CITY OF PORTLAND, MAINE  
DEVELOPMENT REVIEW APPLICATION  
PLANNING DEPARTMENT PROCESSING FORM  
D.R.C. Copy

12/23/99  
Application Date  
Pre fab. single family home  
Project Name/Description

137 - 137 Hobart St, Portland Maine 04103  
Address of Proposed Site  
197 K-1,2,19,20 co. of Osgood  
Assessor's Reference: Chart-Block-Lot

**DRC Conditions of Approval**

**SITE PLAN**  
 HOBART STREET  
 PORTLAND, MAINE

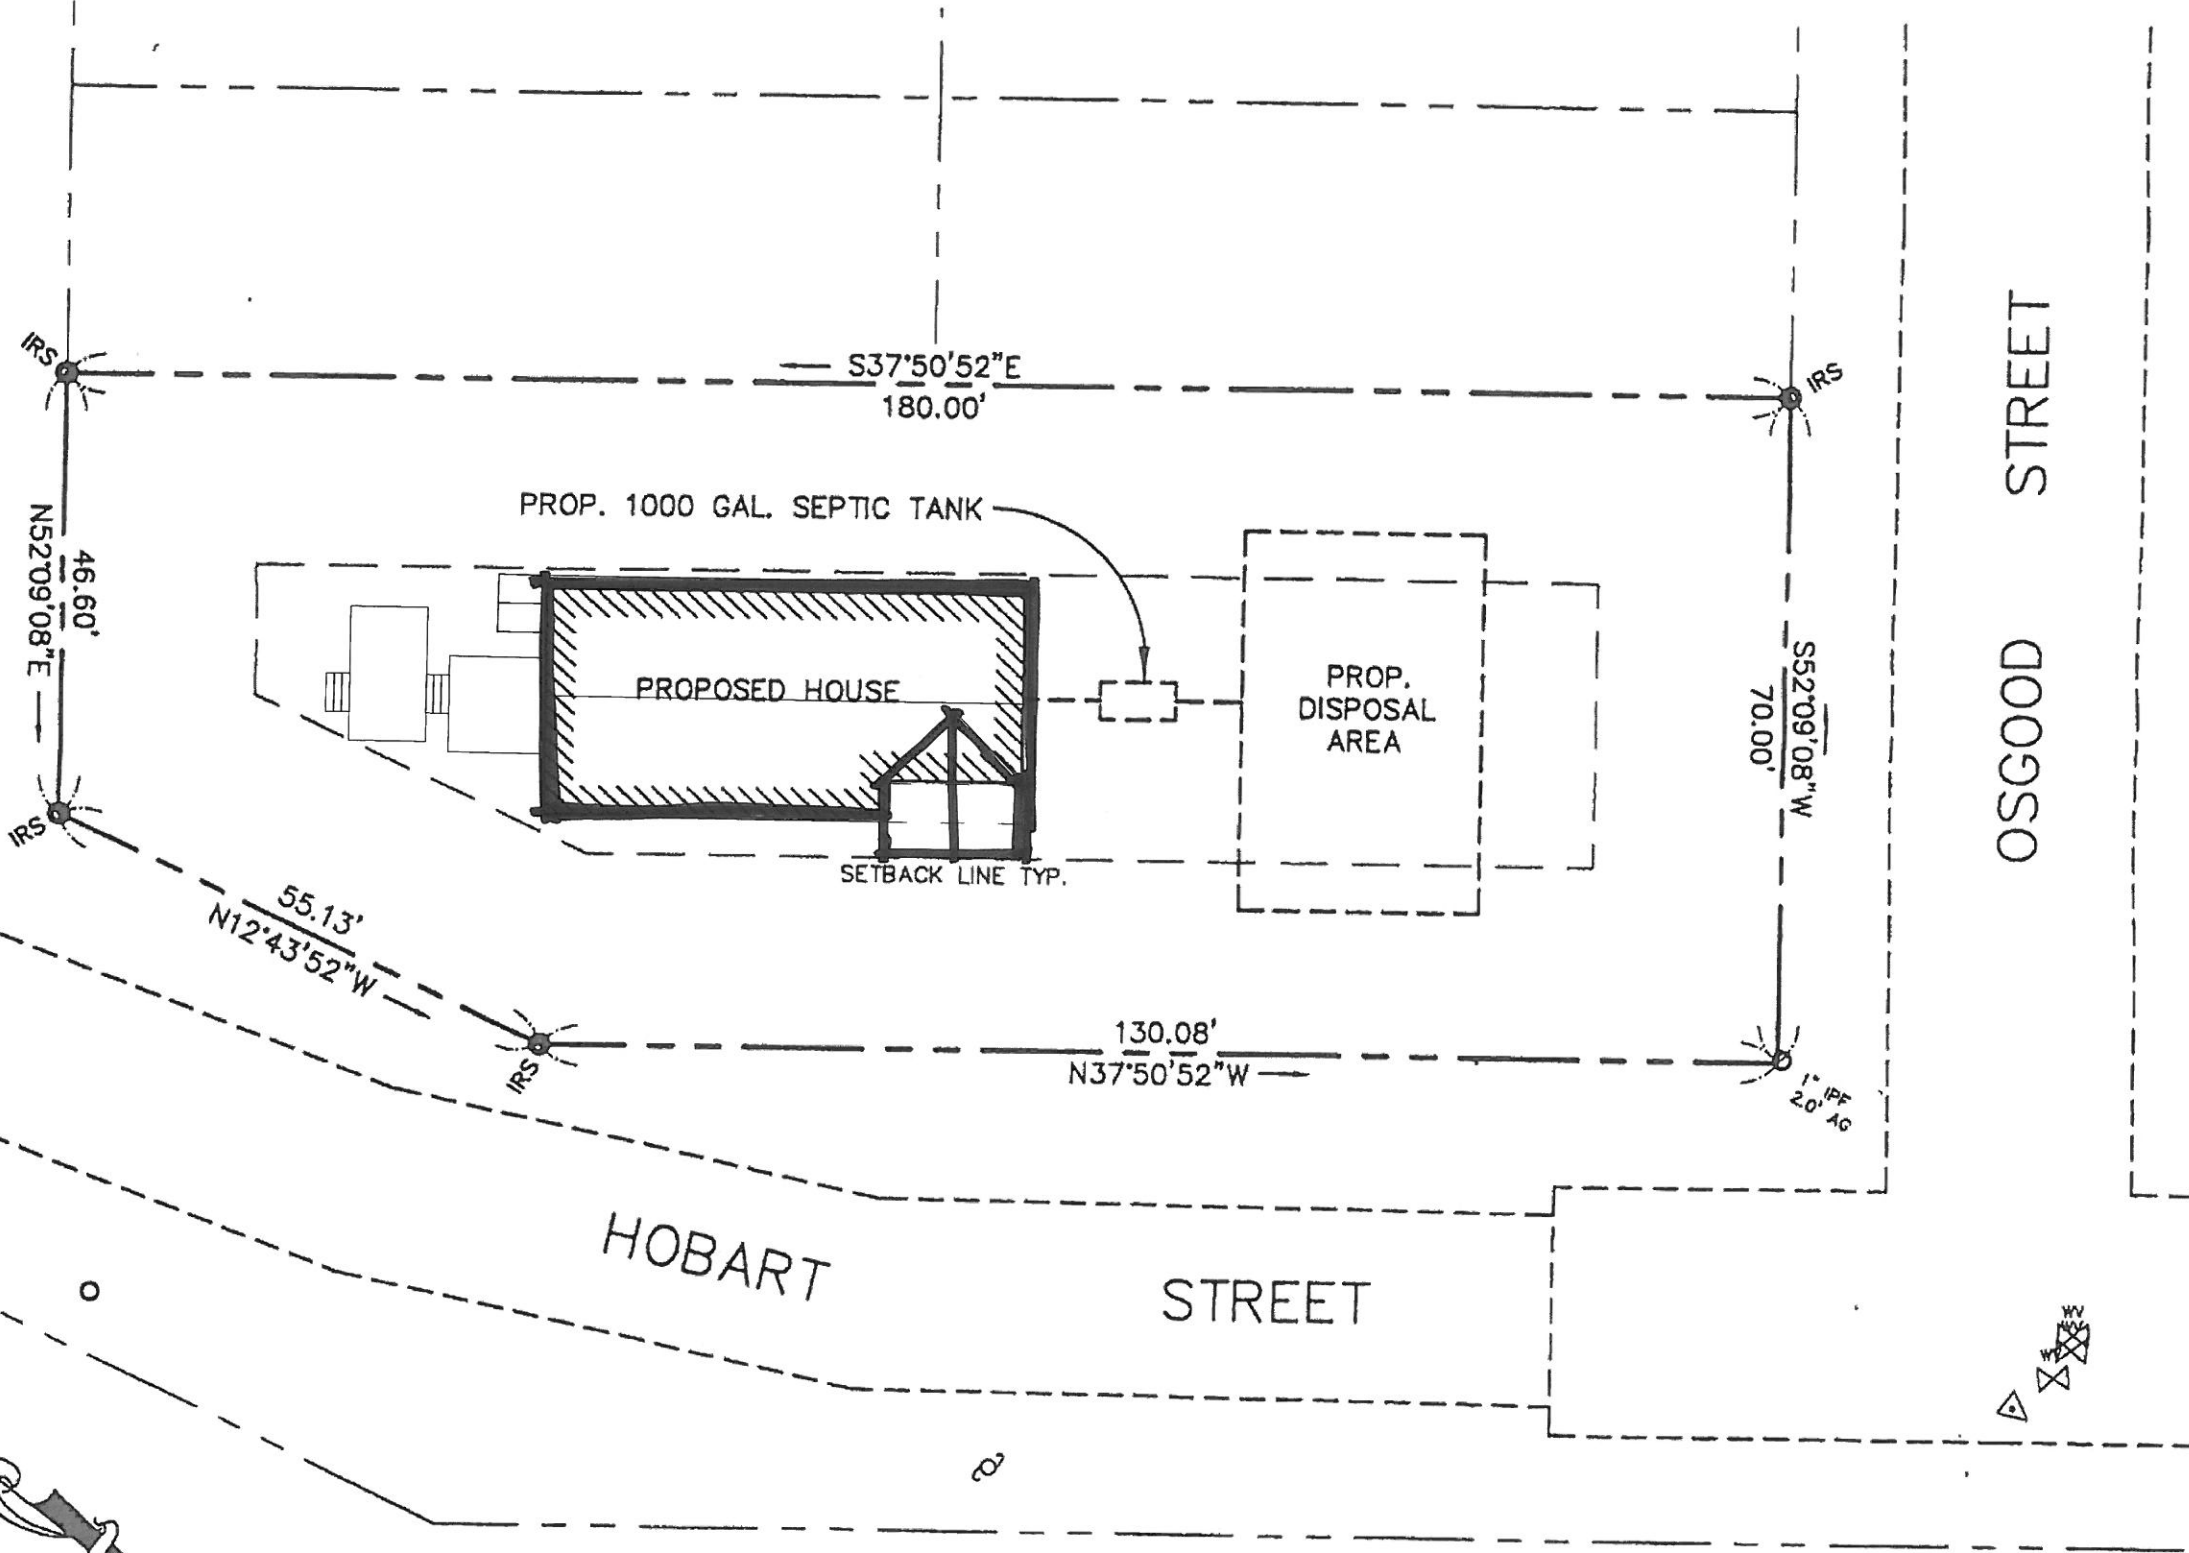
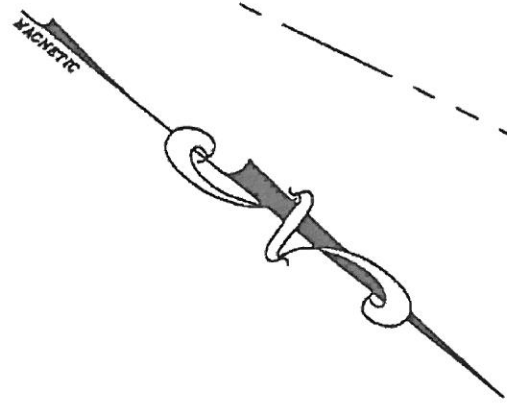
Show all utility connections: water, sanitary, sewer, storm drain, electric, telephone, cable.

A drainage plan shall be submitted to and approved by Development Review Coordinator showing first floor elevation (FFE), sill elevation (SE), finish street/curb elevation, lot grading, existing and proposed contours, drainage patterns and paths, drainage swales, grades at or near abutting property lines, erosion control devices and locations and outlets for drainage from the property.

Applicant will be required to install additional silt fence, extending silt fence along the entire southwest property line.

1. Plot plan does not show existing and proposed grade contours.
2. Stream limits and or wetlands exist on site and a permit may be required (NRPA). Permit is not issued by city, but my MDEP.
3. \*\* This lot may require the extension of Hobart Street.
4. \*\* This lot will require a turnaround on Hobart Street.
5. Utilities = water-sewer etc. shall be shown on the plot plan.
6. Specific surface restoration and stabilization of slopes shall be shown on the plot plan. (erosion control mesh- rip rap - or retaining walls, etc.)
